From: [Dan Young](#)
To: [Chace Pedersen](#)
Subject: RE: ACU-23-00003 Atlas - Notice of Application Comment Period Extension
Date: Monday, August 28, 2023 9:00:18 AM

CDS is requesting comments on the following Administrative Conditional Use application: ACU-23-00003 Atlas

SHEET TITLE:
SITE PLAN

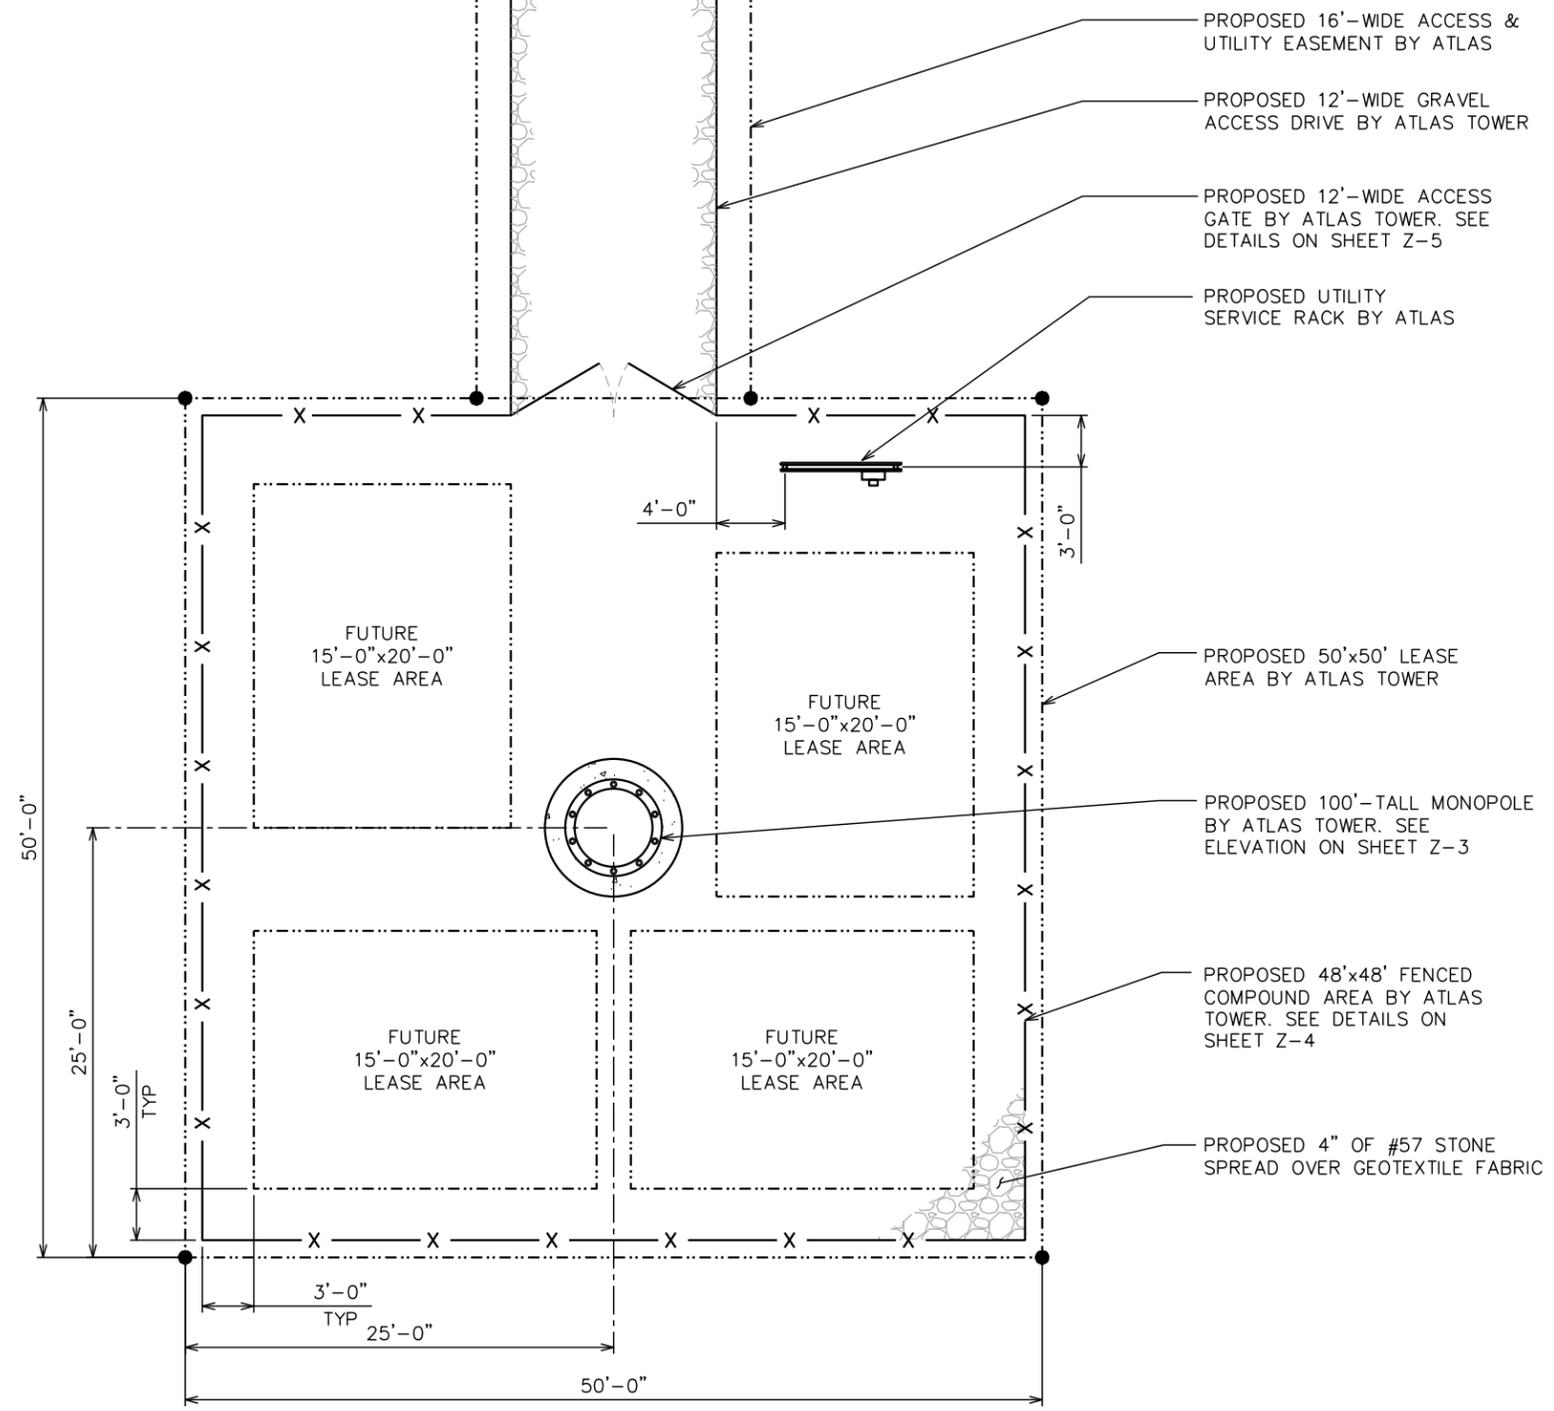
The access roadway shall meet the current Kittitas County driveway standards. If the access roadway exceeds 150 feet than an approved turnaround shall be installed per Appendix D of the international Fire Code.

GATE LOCK DETAIL

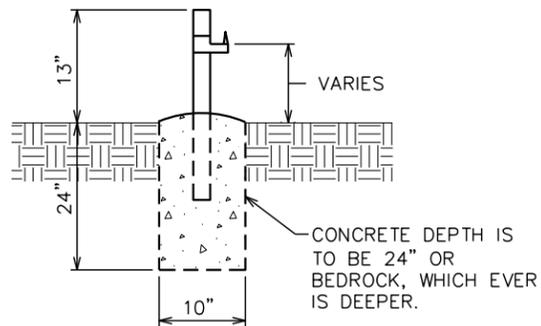
The gate shall have an approved Knox Key access.
